**Re: Comment Letter for Proposed Redevelopment of 6950 SE Maker Street
Permit No. 2207-019**

On behalf of our client, Dan Grove, we submit these comments on the permit application for the proposed demolition and rebuild of the home located at 6950 SE Maker Street (the “Strand Property”) pending under Permit No. 2207-019 (the “Permit”). Mr. Grove owns the house immediately adjacent to the east of the Strand Property and is acutely familiar with the issues discussed in this letter. Mr. Grove respectfully requests notice and a copy of the permit decision once made by the City.

MERCER RESIDENCE  
6950 SE MAKER ST MERCER ISLAND, WA

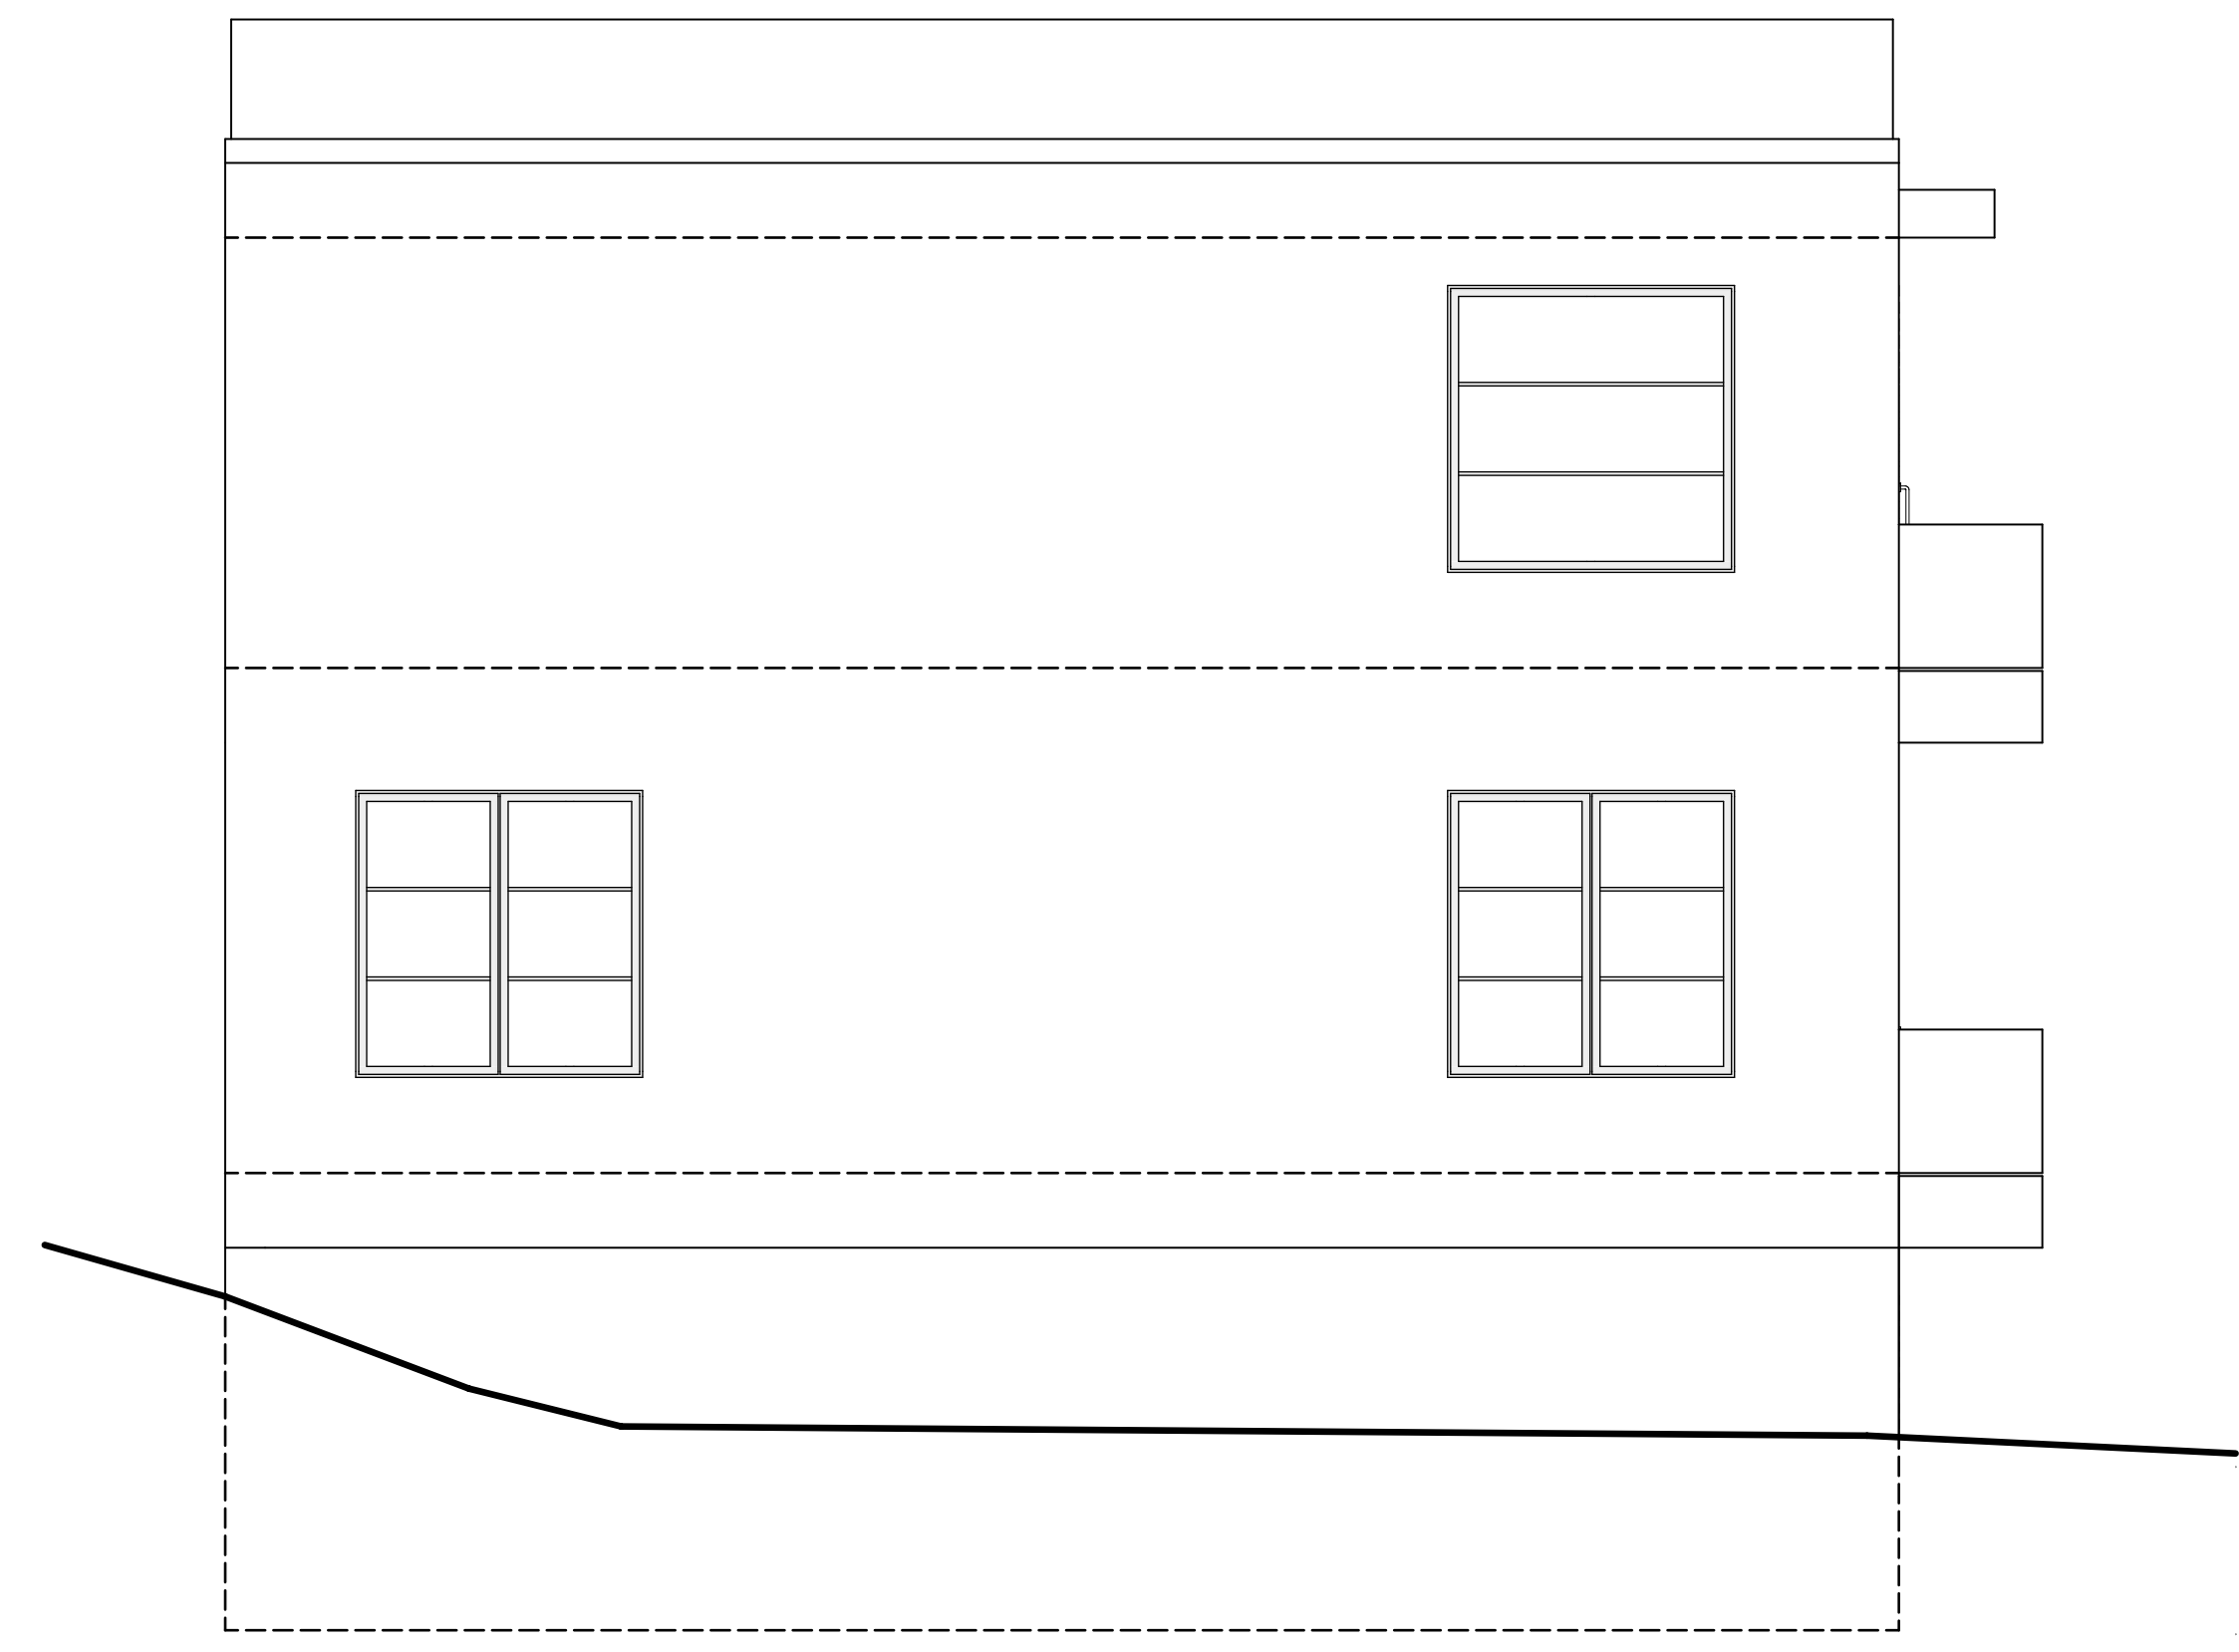
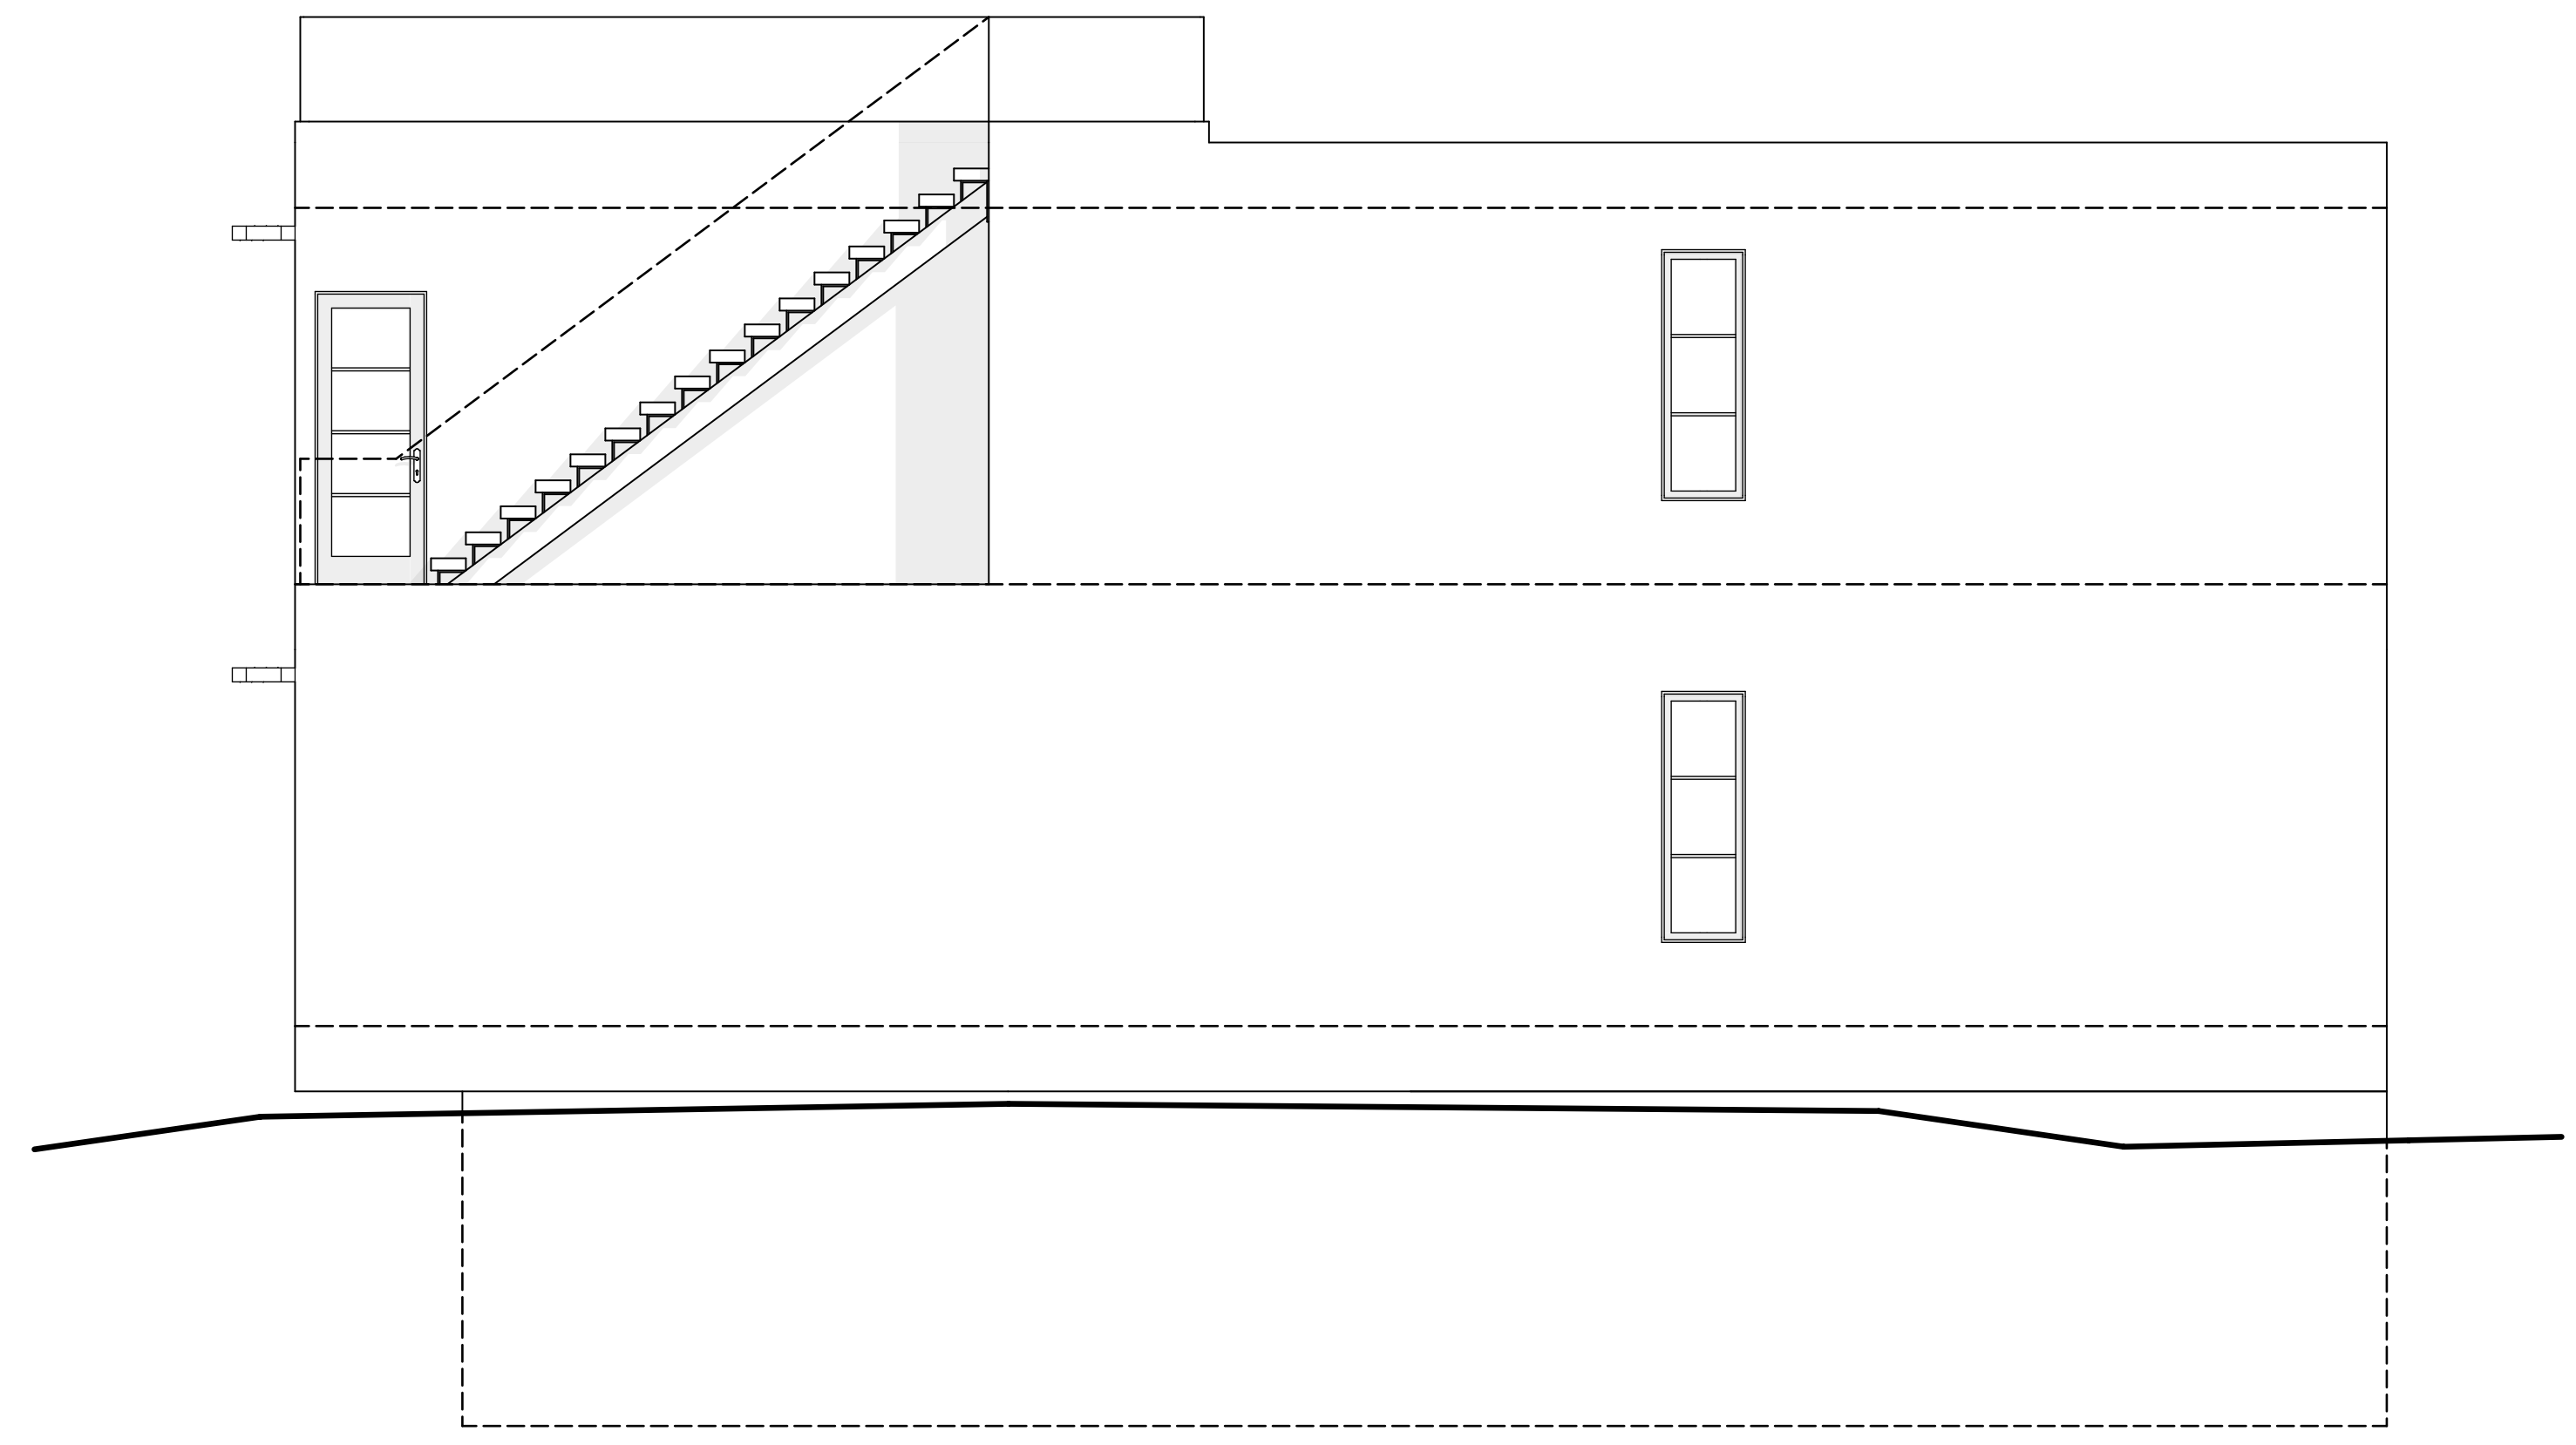
finished floor elevation of the basement as 228.7' (Sheet 1), the proposed finished floor elevation as 227.72' (Sheet C-2), and the existing grade as 235.24' (Sheet A3.1).

Evidence from pre-development survey documents shows the existing grade as several feet lower than the existing grade as calculated in the design plans. This translates to an ABE closer to 227.0’, not 233.06’ as identified in the Plan Set (Sheet A3.1).

Summary of Permit’s Incorrect Calculations	
(Inaccurate) ABE	233.06’
Height Limit	30’
(Inaccurate) Maximum Allowable Building Height	263.06’
Proposed Height	261.43’

But, instead of 263.06', the correct maximum allowable height is closer to 257.0' because the ABE is more accurately 227.0'. The relevant surveys and design plans show the correct calculations for this project are as follows:

The Strand Property slopes down primarily from east to west. The existing grade at the furthest downhill extent of the proposed building ranges from 223' to 261.43'.¹² And, the rooftop railings described in the Plan Set add approximately 3 feet to the structure (Sheet A3.1). Measuring from the existing grade at the furthest downhill extent to the top of the exterior wall façade equals roughly 8 feet above the allowable 30-foot limit. The table below provides this comparison:
